CITY OF ALBUQUERQUE  
PLANNING DEPARTMENT  
DEVELOPMENT REVIEW BOARD

**Project# 1004039**

14DRB-70123 MINOR - PRELIMINARY/ FINAL PLAT APPROVAL  
14DRB-70159 VACATION OF PRIVATE EASEMENT

**CITY OF ALBUQUERQUE  
PLANNING DEPARTMENT  
May 21, 2014  
DRB Comments**

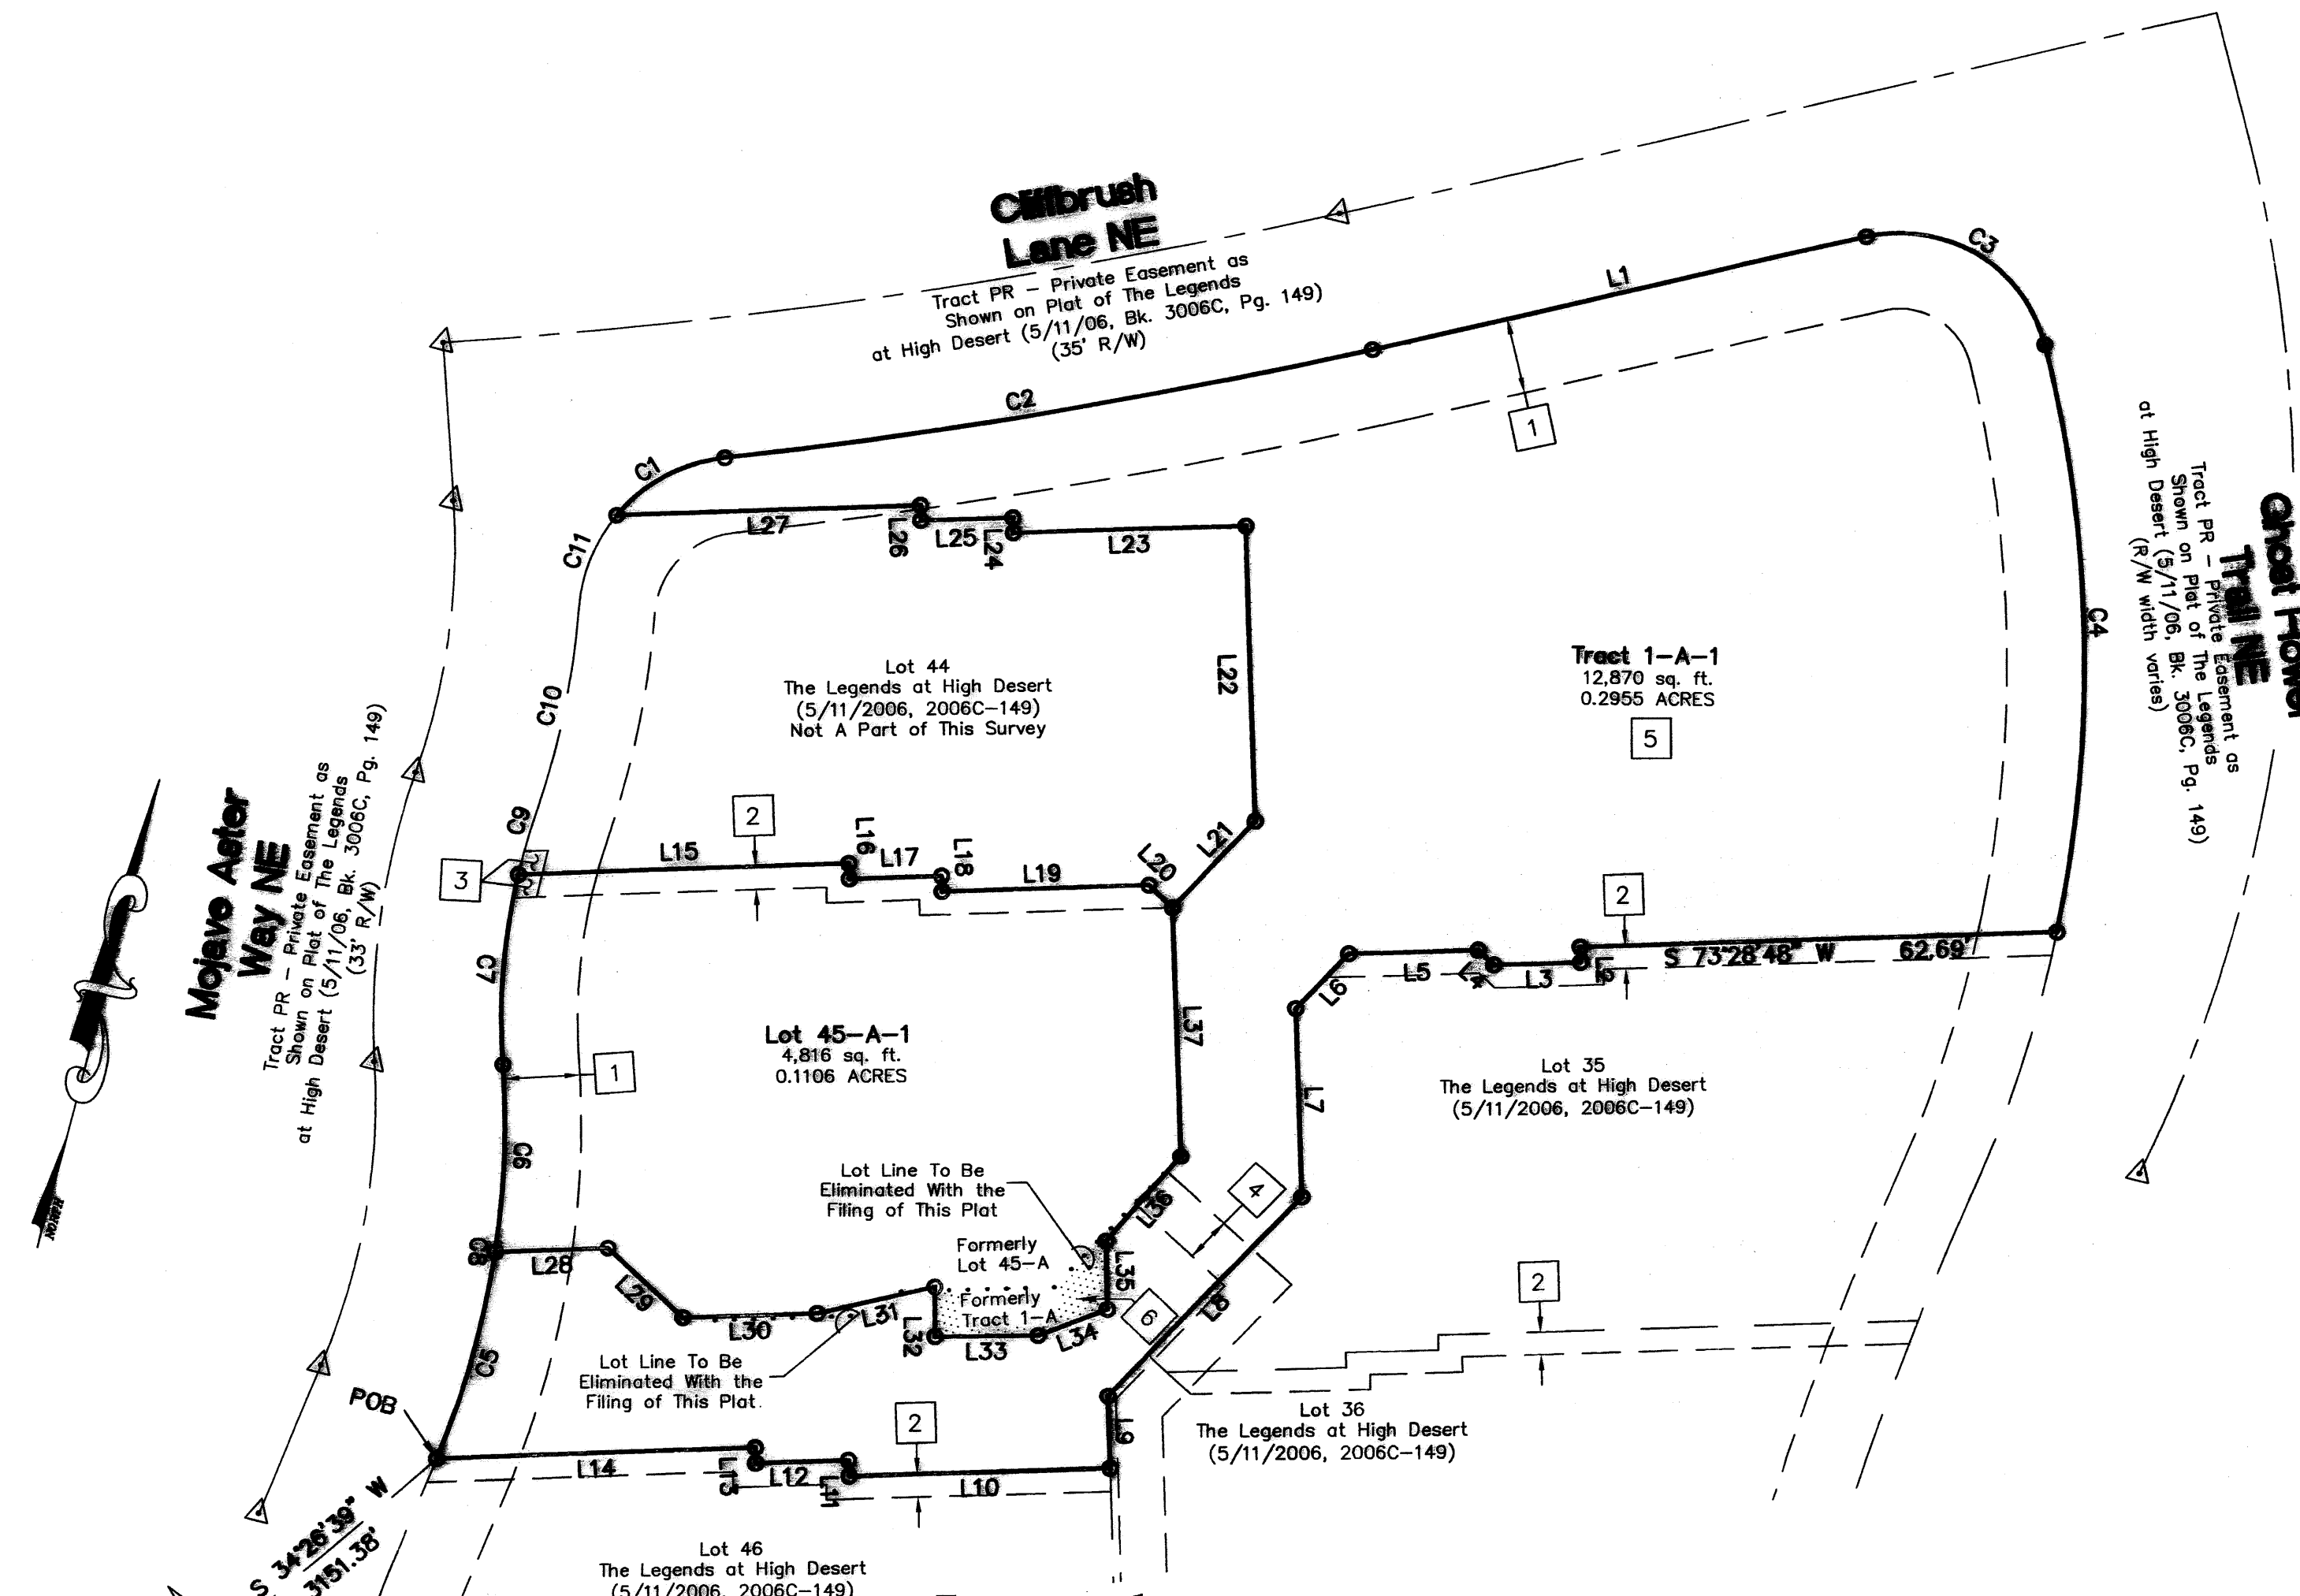
- The narrowest part of the proposed Tract 1-A-1 needs to be dimensioned
- Aerial photography indicates another encroachment on the south side/ Lot 46 that needs to be addressed

Lot 16-A & Lot 17-A  
 Being a Replat of  
 Lot 16 & Lot 17  
 The Legends at High Desert  
 Elena Gallegos Grant  
 Projected Section 26  
 T.11N., R.4E. N.M.P.M.  
 City of Albuquerque  
 Bernalillo County, New Mexico  
 April 2008

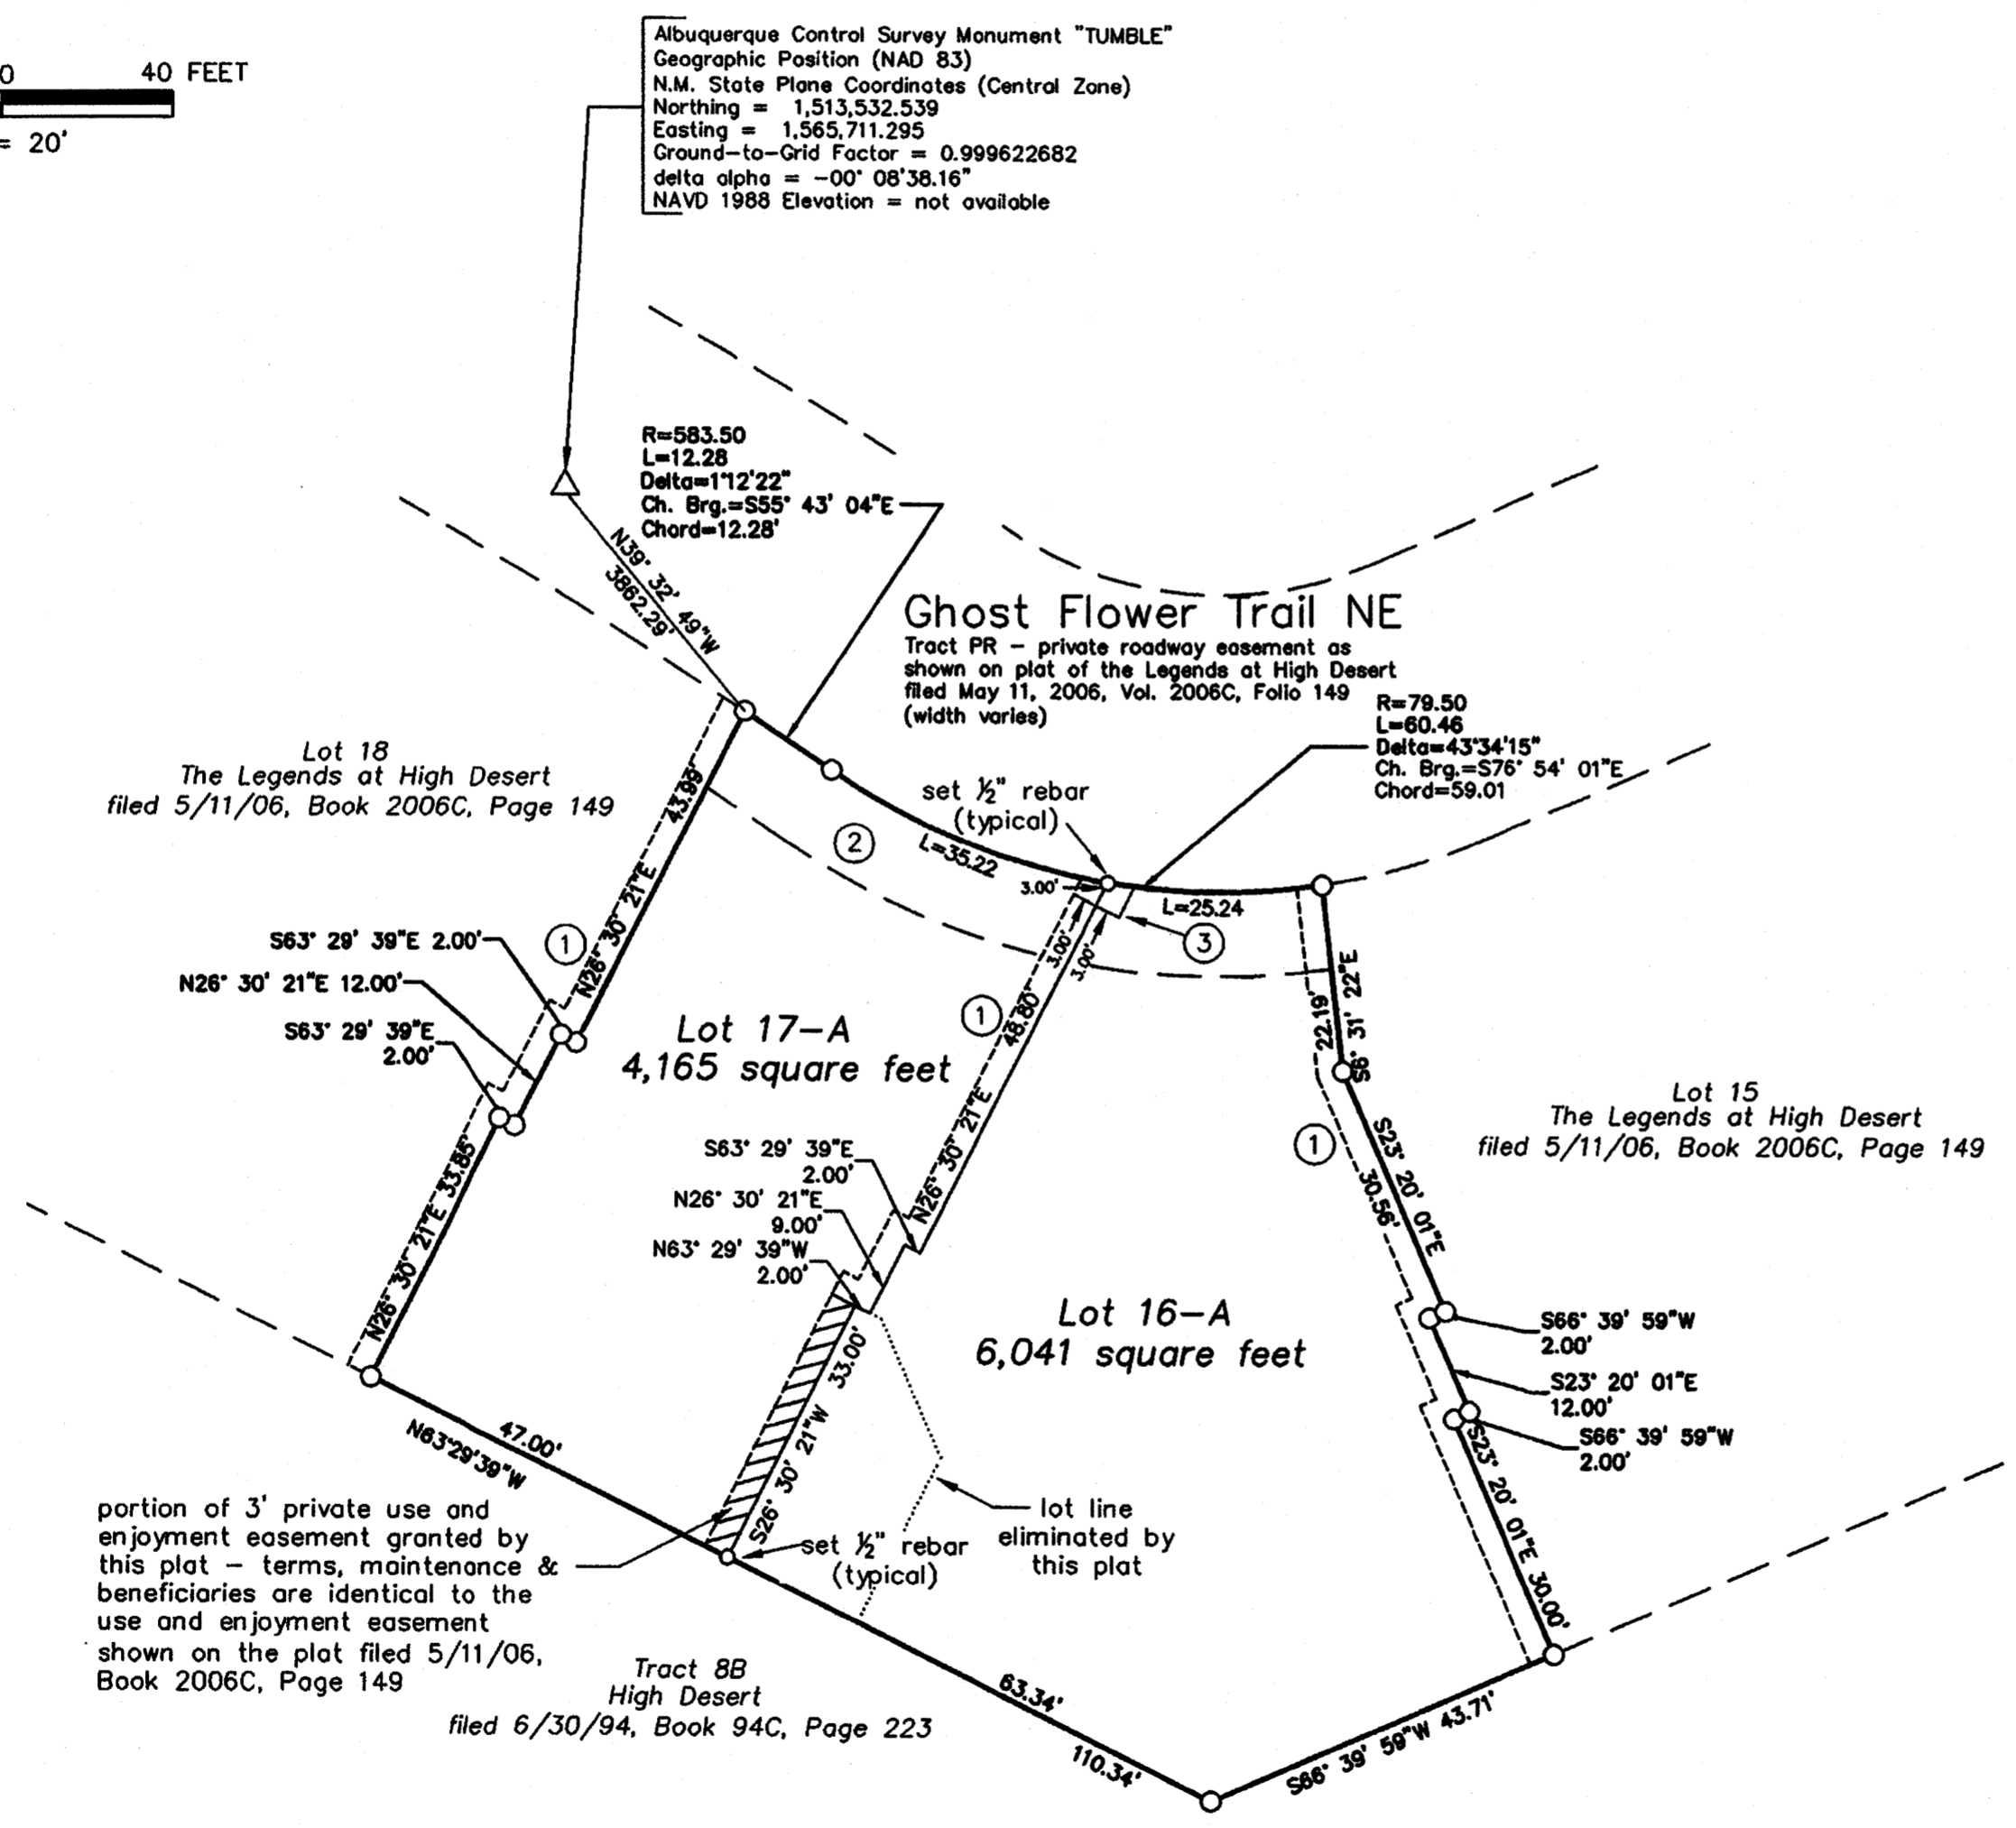
For future reference, please do not identify the property's zoning (Note 2) on the plat. Also, please use language in the solar collector note to be specific to this type of request, i.e. use the words "THIS PLAT" and not "REQUESTED FINAL ACTION" in the beginning of the note and delete the words "OR SITE DEVELOPMENT PLAN FOR SUBDIVISION" from the end of the note.

Lot 45-A & Tract 1-A  
 Being a Replat of  
 Lot 45 & Tract 1  
 The Legends at High Desert  
 Elena Gallegos Grant  
 Projected Section 26  
 T.11N., R.4E. N.M.P.M.  
 City of Albuquerque  
 Bernalillo County, New Mexico  
 November 2007

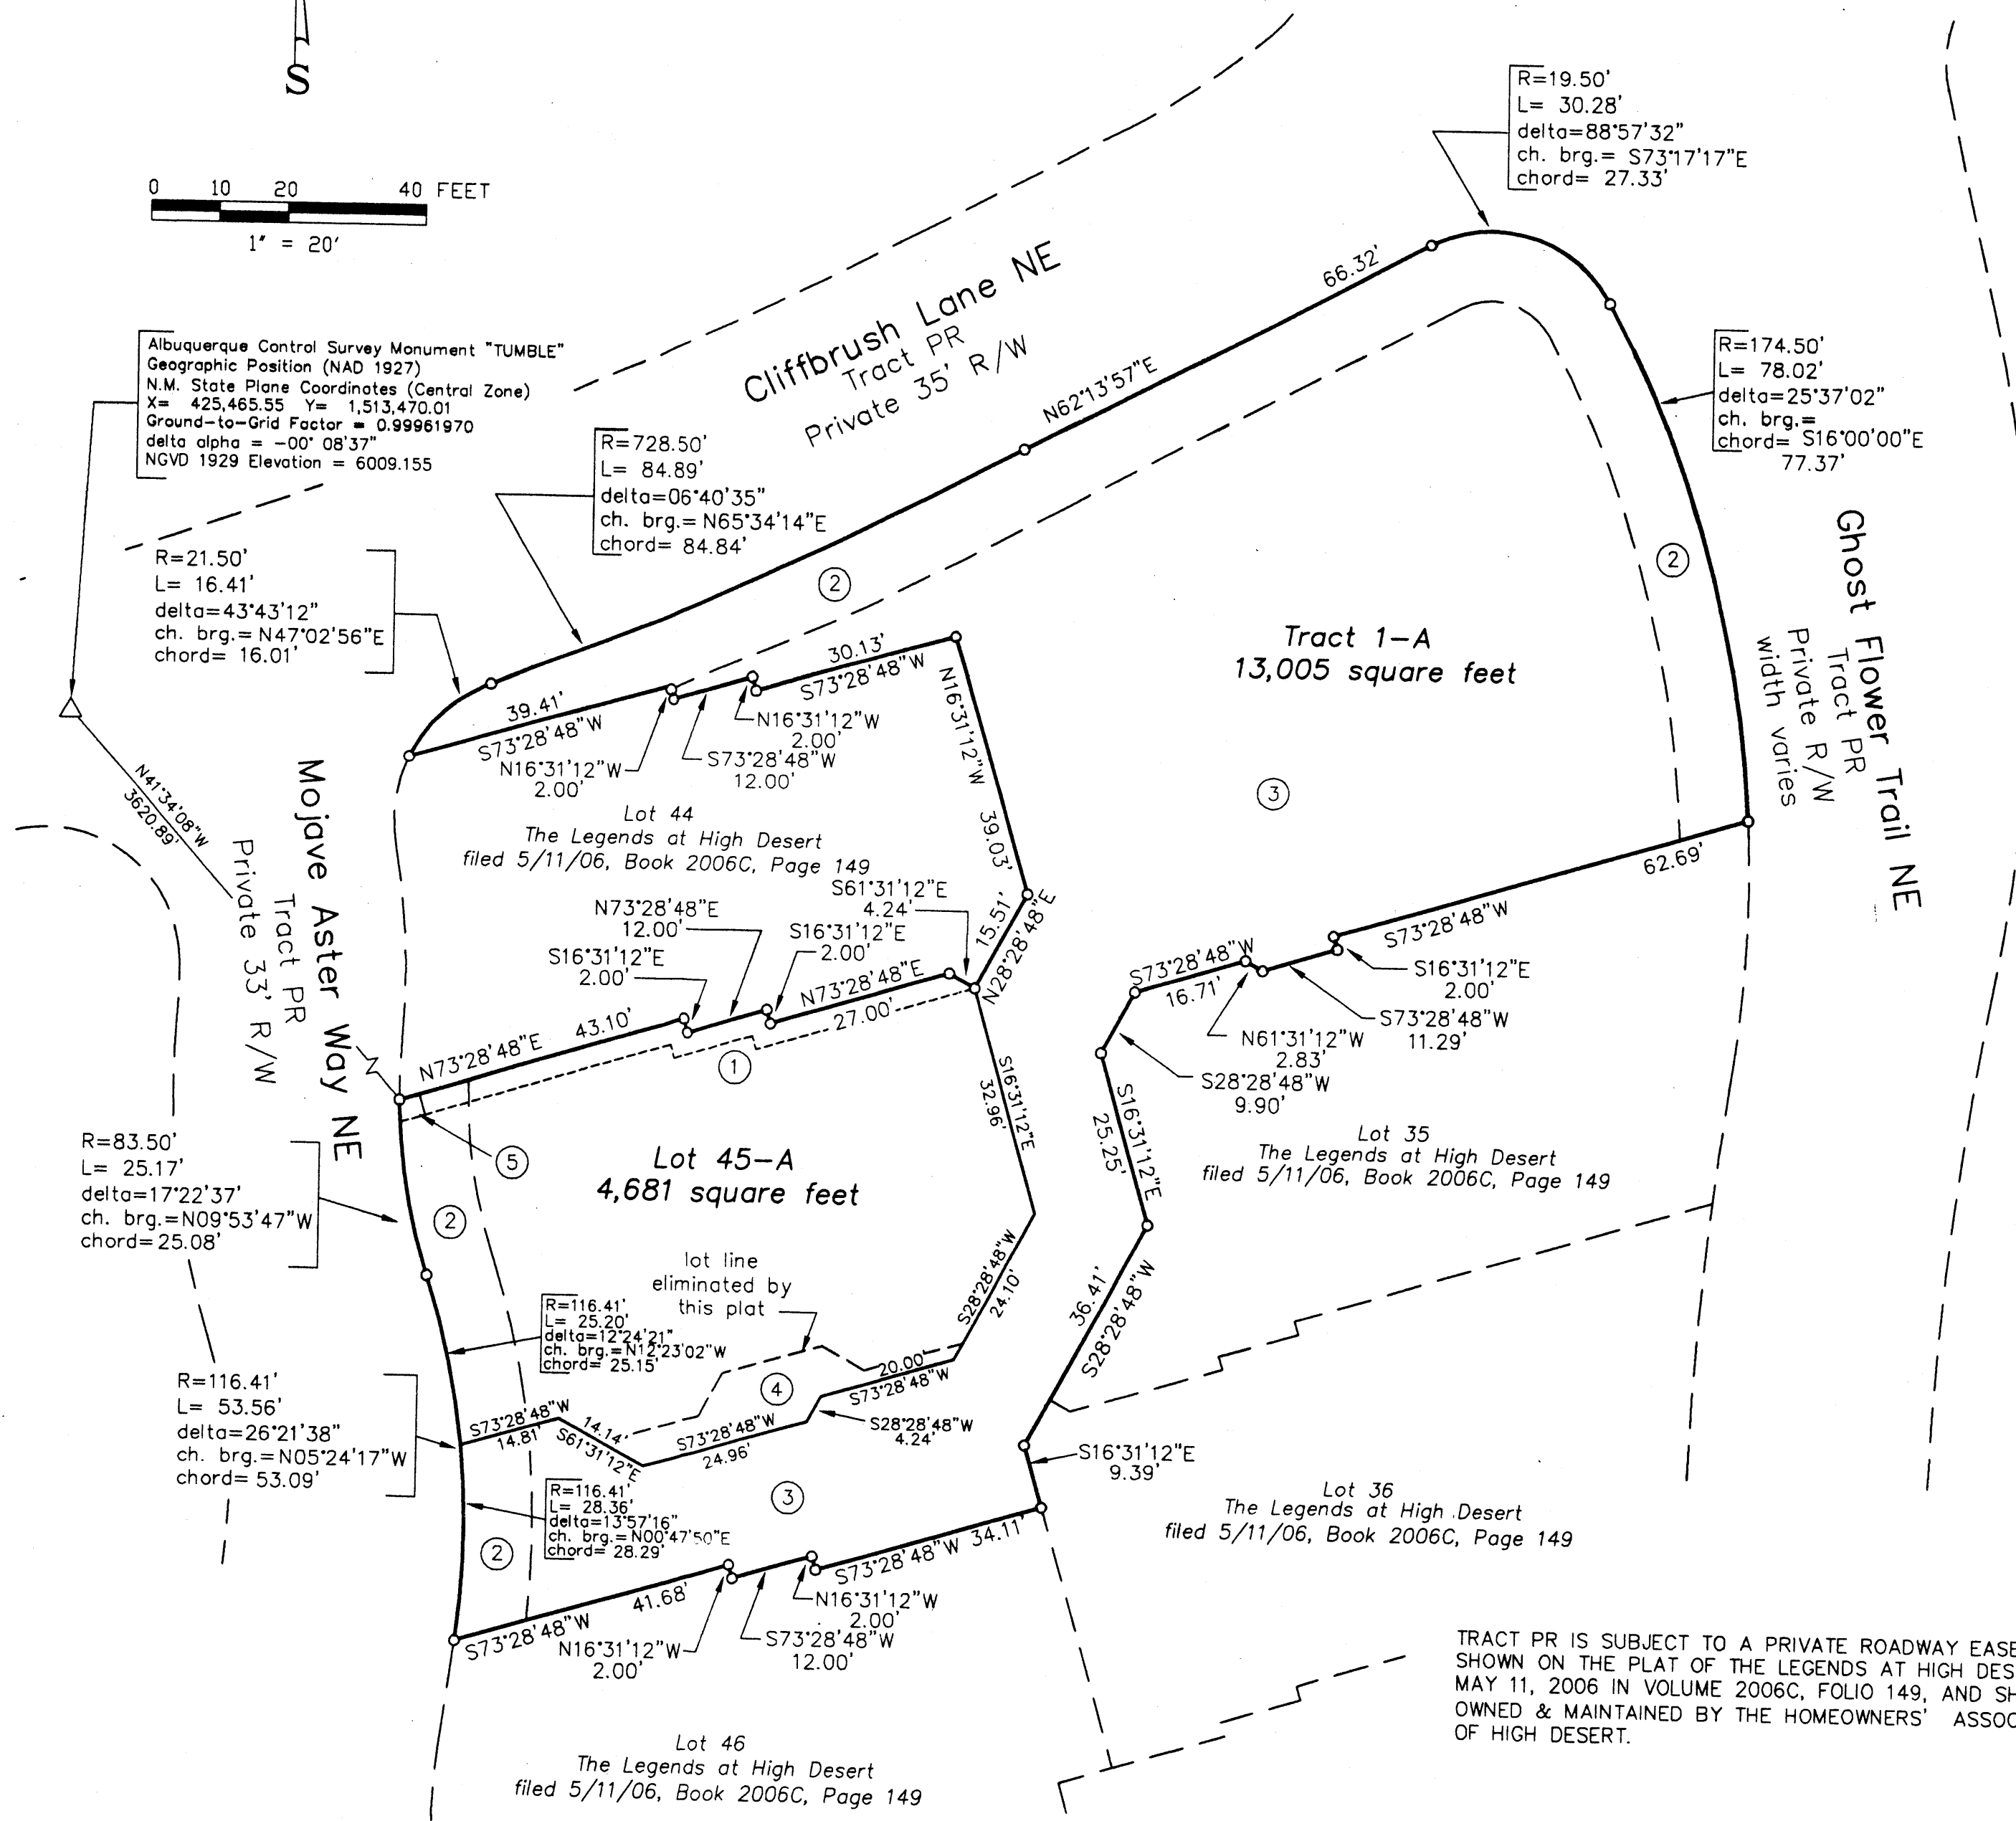
Letter of concurrence for vacation must be from the beneficiary, i.e. the Homeowner's Association (not just as property owner).
